**100 BENNELONG ROAD, OLYMPIC
PARK: CHILDCARE CENTRE**

ACCESS REVIEW

Morris-Goding Accessibility Consulting

13th June 2014

1 Detail Ground Plan through Childcare 1:25

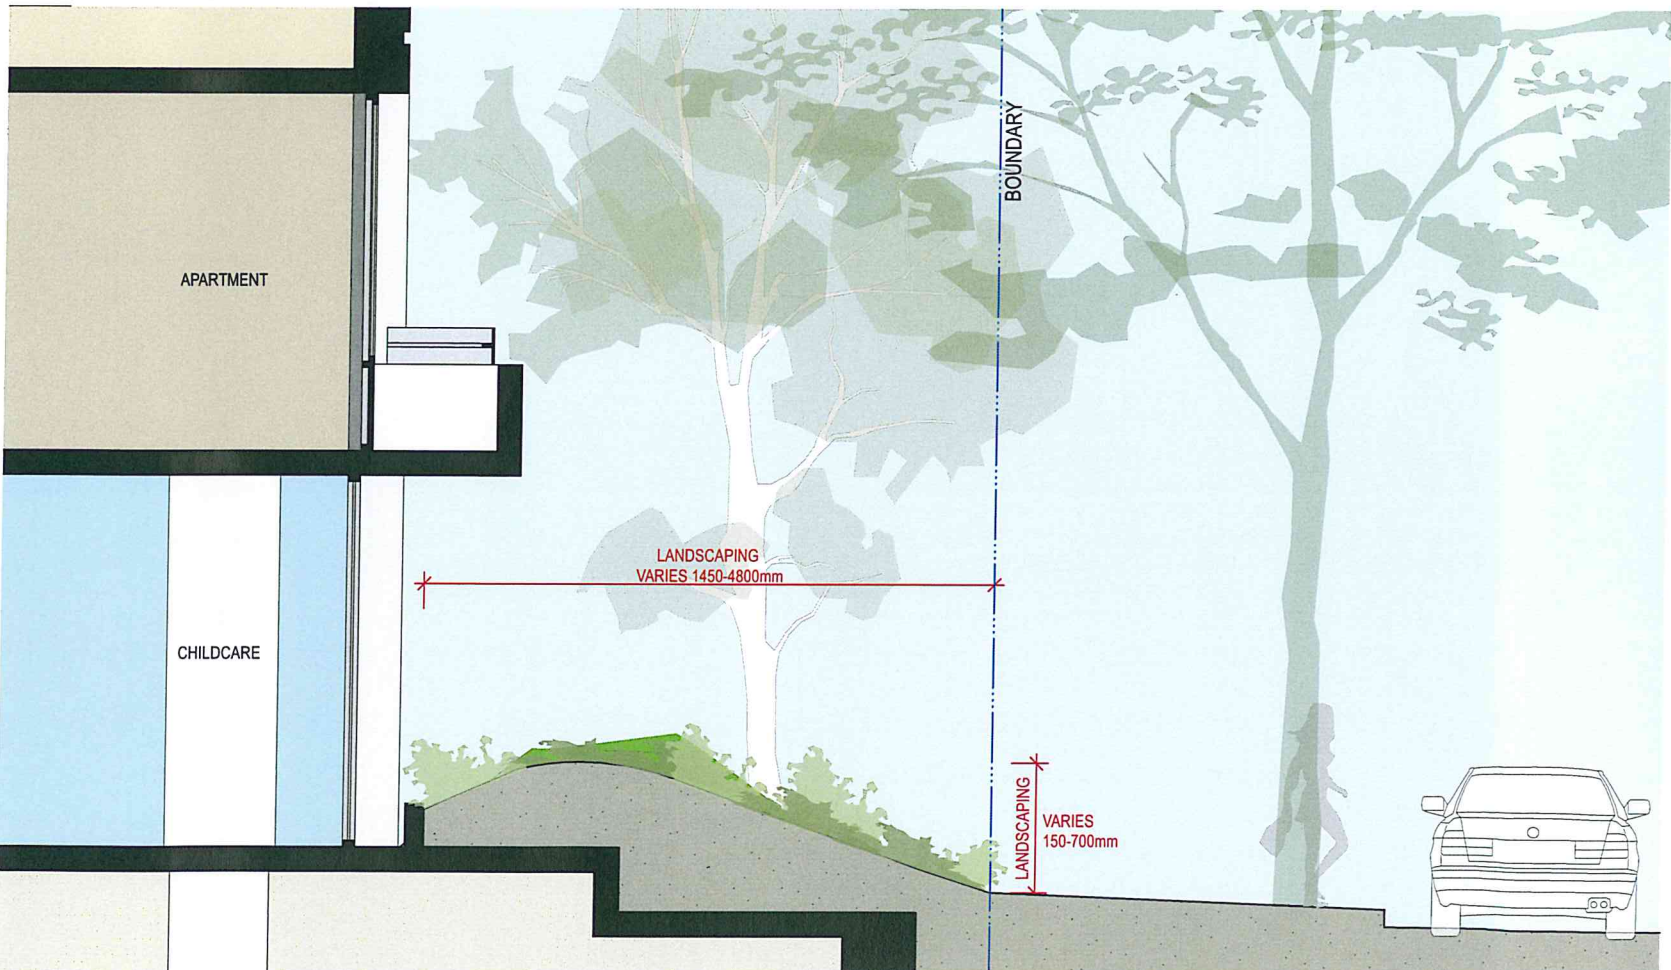
The door has an 850mm clear width with suitable latch side clearance compliant with AS1428.1 and the DDA Premises Standards. There is a sign-in desk located on the internal latch of the door which will need to be relocated to ensure suitable clearances in accordance with AS1428.1.

In general, internal doors have appropriate 850mm clear widths compliant with AS1428.1 and the DDA Premises Standards. Review of latch side clearances is required to some doors to ensure suitable access in accordance with AS1428.1 circulation requirements.

Hinged doors opening out to the outdoor play area appear to have 750mm clear widths which will require modification to ensure compliance with AS1428.1.

There is an accessible WC located adjacent to the reception area.

The bathroom has appropriate internal dimensions to allow for suitable clearances around the pan, basin and shower. The basin will need to be relocated to ensure suitable clearances outside of the shower recess in accordance with AS1428.1.

There are male and female ambulant cubicles located adjacent to the meeting/lunch room.

The cubicles have suitable 750mm clear width doors, however the basin encroaches in the door clearances. The cubicles have an 865mm clear width which will require modification to ensure suitable compliance with AS1428.1.

- (i) Ensure a suitable 530mm clear internal latch side clearance compliant with AS1428.1 and the DDA Premises Standards.

- (i) Ensure the staff room and office interview doors have appropriate external latch side clearances of 510mm in accordance with AS1428.1.
- (ii) Ensure the bathroom 1 and office interview doors have appropriate internal latch side clearances of 530mm in accordance with AS1428.1.
- (iii) Ensure all hinged doors opening to outdoor play areas have minimum 850mm clear widths (920mm door leafs) in accordance with AS1428.1 and the DDA Premises Standards.

- (i) Rotate the basin to be on the adjacent wall (opposite the shower head) to ensure suitable clearances outside the shower recess in accordance with AS1428.1.

- (i) Ensure cubicle doors have minimum 900mm x 900mm clearances outside of the door swing in accordance with AS1428.1.
- (ii) Pan requires a minimum 900mm x 900mm clearance in front of the pan to allow for suitable clearances compliant with AS1428.1.
